December 2, 2016

SUBJECT: **Modification Request of Section 404 Regional General Permit No. 31 and Section 401 General Water Quality Certification No. 3886** for the proposed Interstate 85 (I-85) Widening and Interchange Improvements from north of NC 73 (Davidson Highway / Exit 55) to north of SR 2180 (Lane Street/Exit 63), Cabarrus & Rowan Counties, Divisions 9 and 10. Federal Aid Project No. FANHIMF-085-2(61)55, TIP Project No. I-3802A.

The permit drawings for these three sites have been revised to depict the additional bank stabilization at Site 2, temporary impacts at Site UC-1, and the additional bank stabilization at Site 18. They have been included in this modification request along with the revised impact summary tables.

PROJECT REFERENCE NO. I-3802A	SHEET NO. 22A
RW SHEET NO. ROADWAY DESIGN ENGINEER	HYDRAULICS ENGINEER
BLYTHE

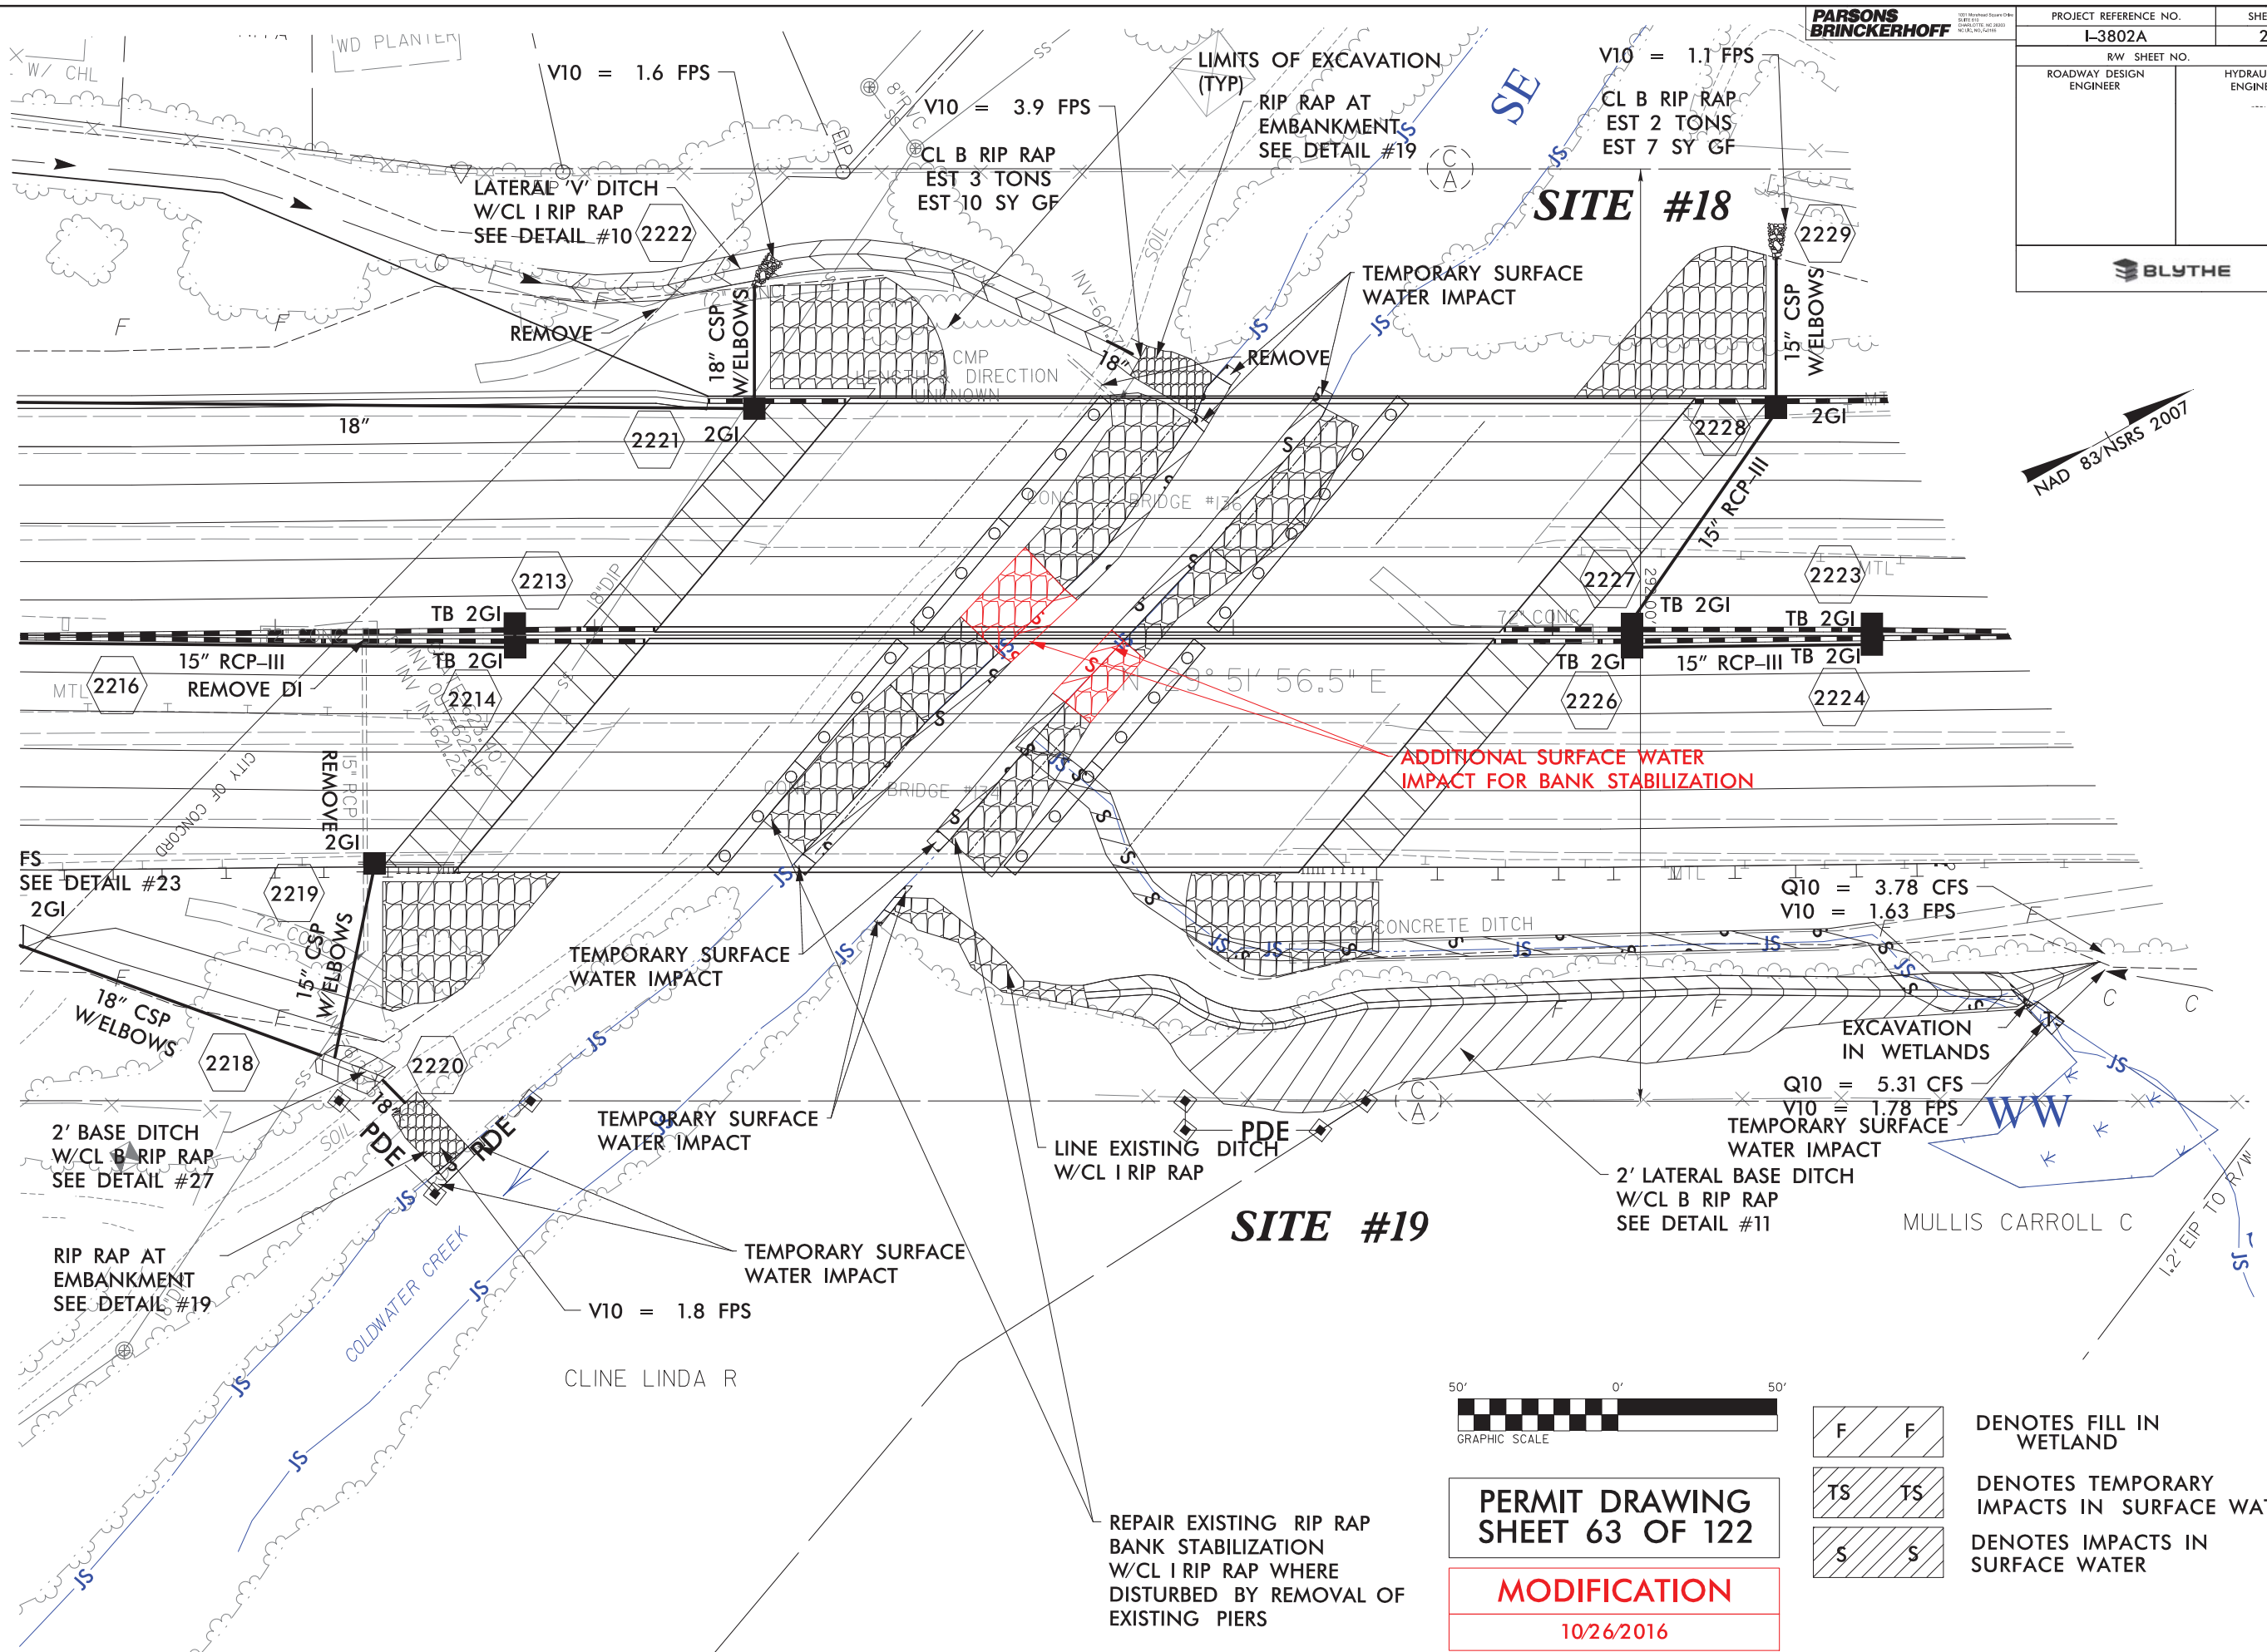
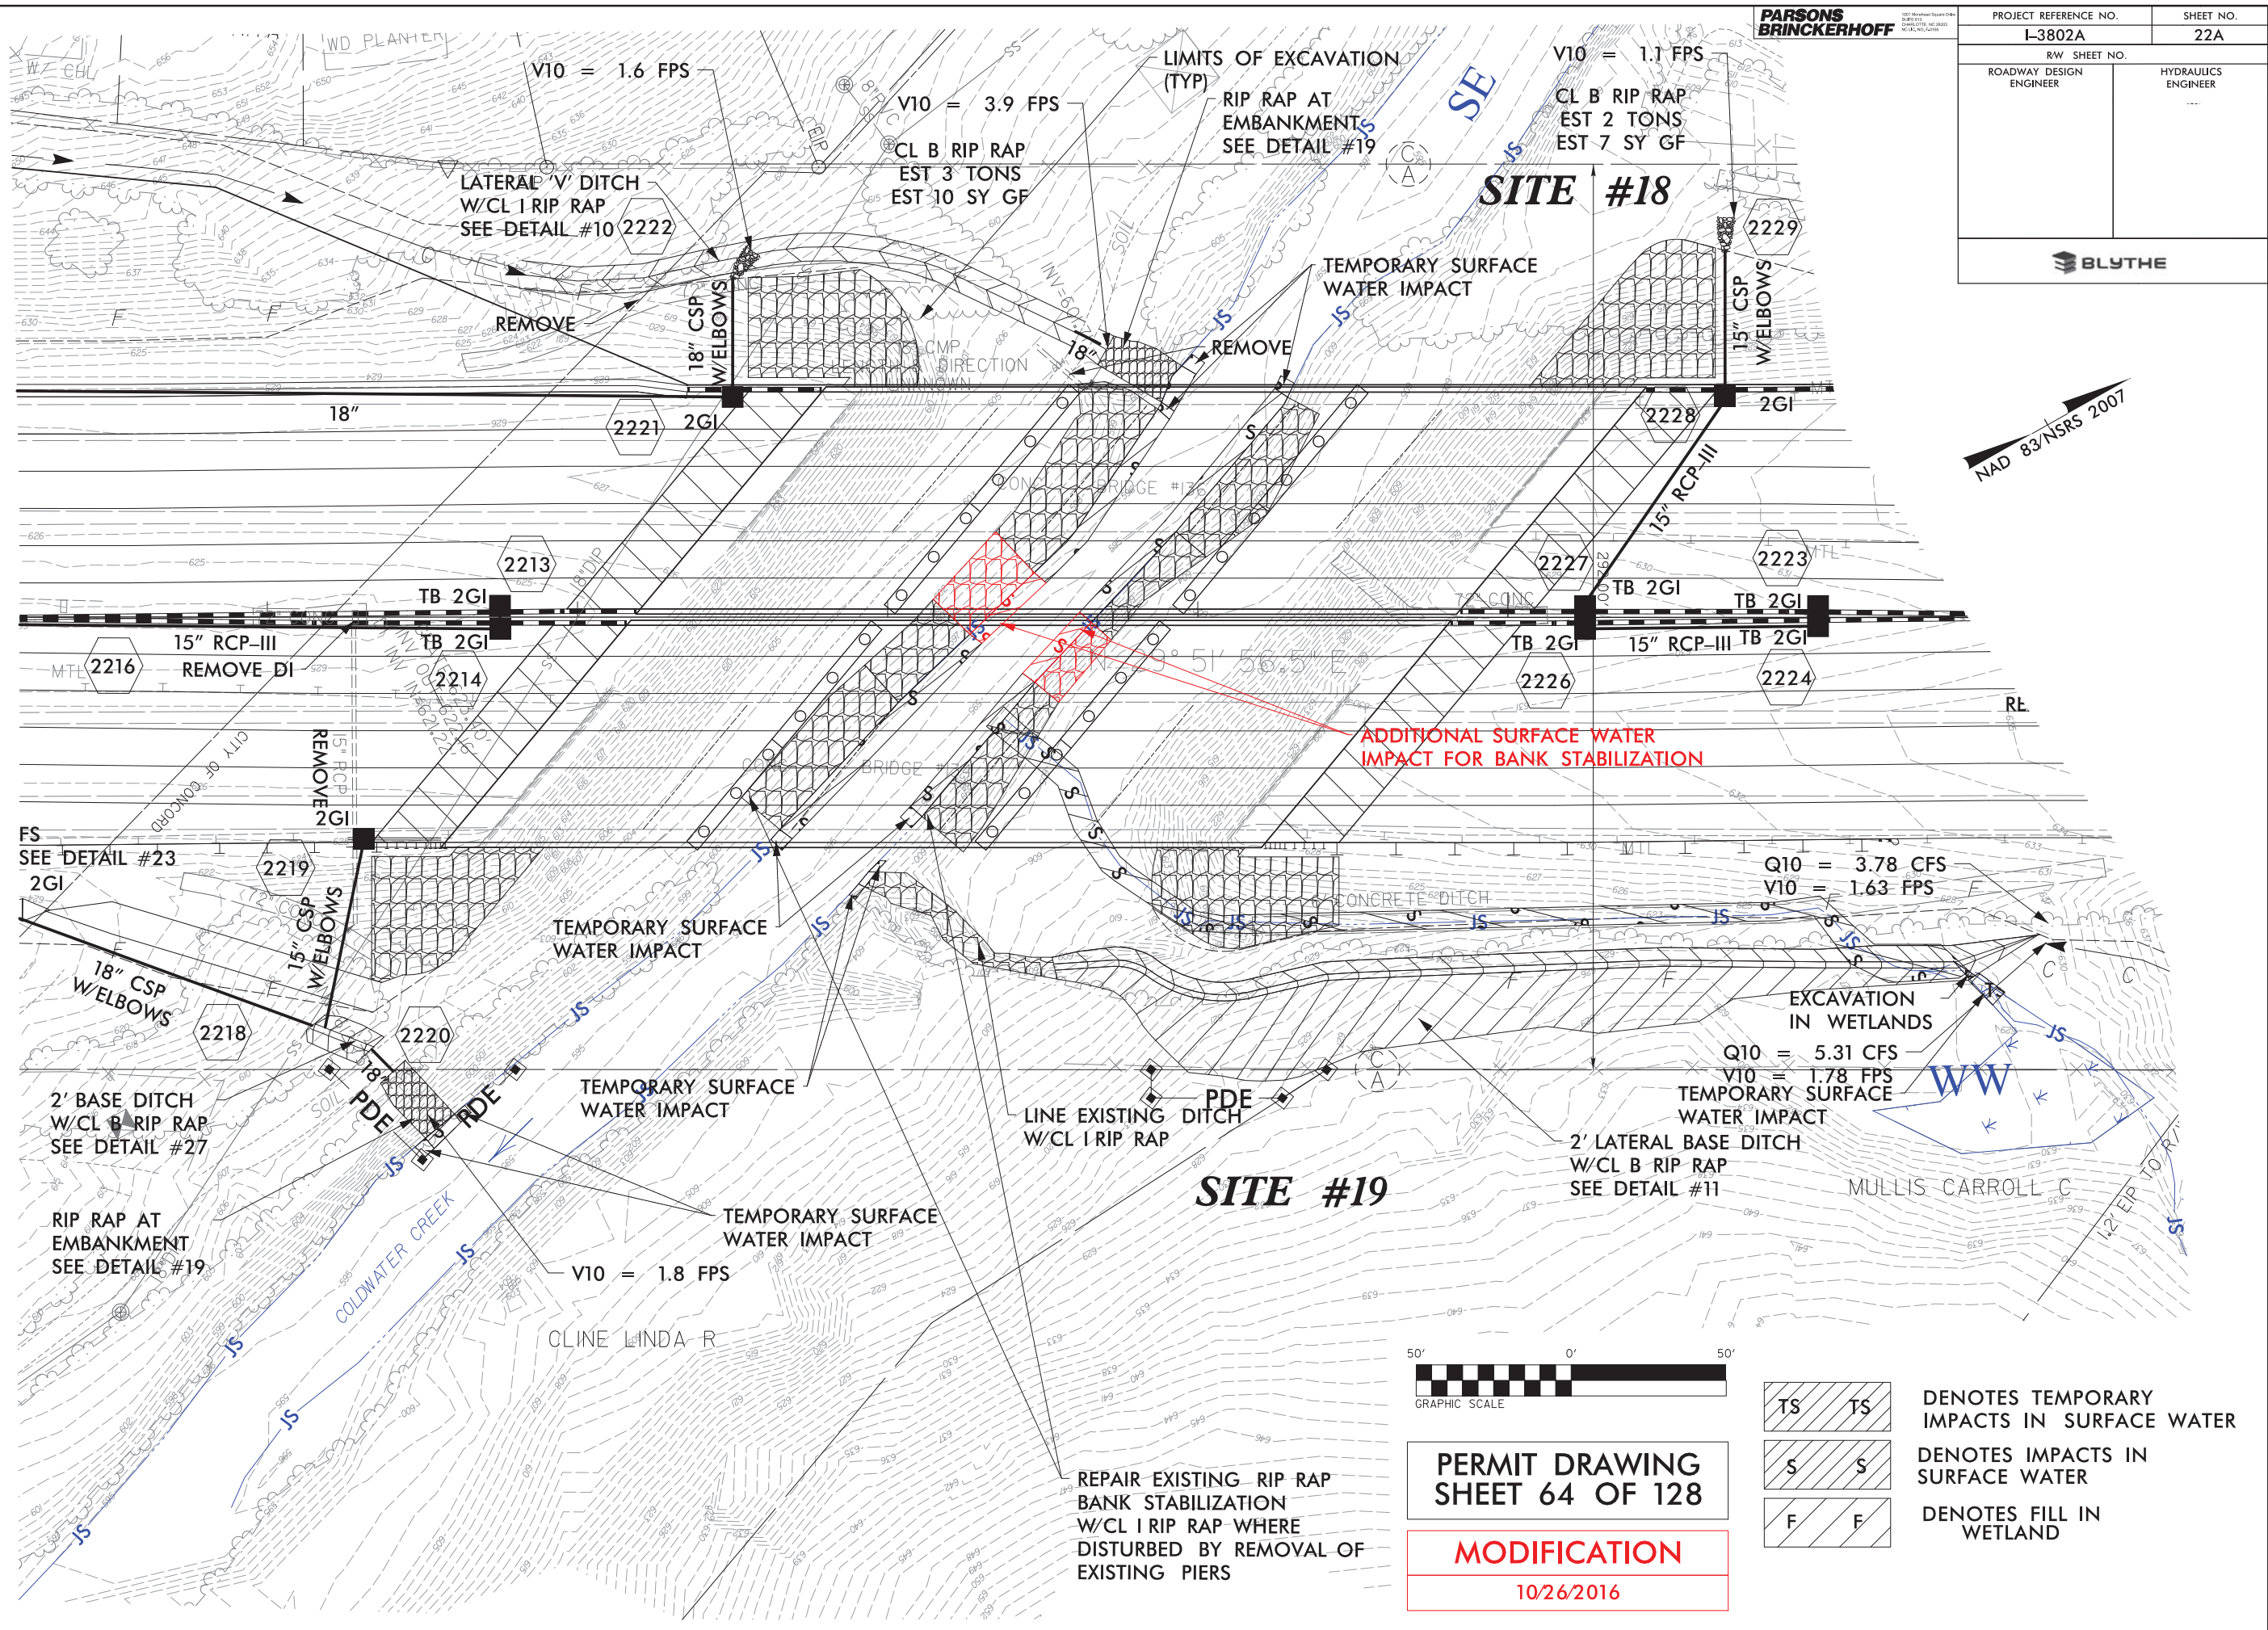
On November 17, 2015, representatives from NCDOT met on site with Ms. Donna Hood (N.C. Division of Water Resources [NCDWR]) to conduct a project review. During the site meeting Ms. Hood recommended that additional riprap be placed under the Cold Water Creek Bridge. The contractor also required a temporary crossing at the same

location. A modification request for the addition of 66 linear feet of temporary stream impact due to the placement of the temporary causeway and 30 linear feet of permanent impact due to bank stabilization at Site 18 was initially requested on February 18, 2016. The modification to the Section 401 certification was approved by NCDWR on March 22, 2016. The Section 404 modification request has not yet been approved by the U.S. Army Corps of Engineers (USACE). Since the February submittal, it has been determined that the temporary crossing is no longer needed. Additionally, the riprap bank stabilization was installed at the site by the contractor prior to receiving the USACE permit modification, most likely due to a misunderstanding that both the Section 404 and 401 modifications had been approved. The previously approved 185 linear feet of stabilization, which was permitted by the original permit, and the additional un-permitted 30 linear feet included in the last permit modification request has already been installed at the site.
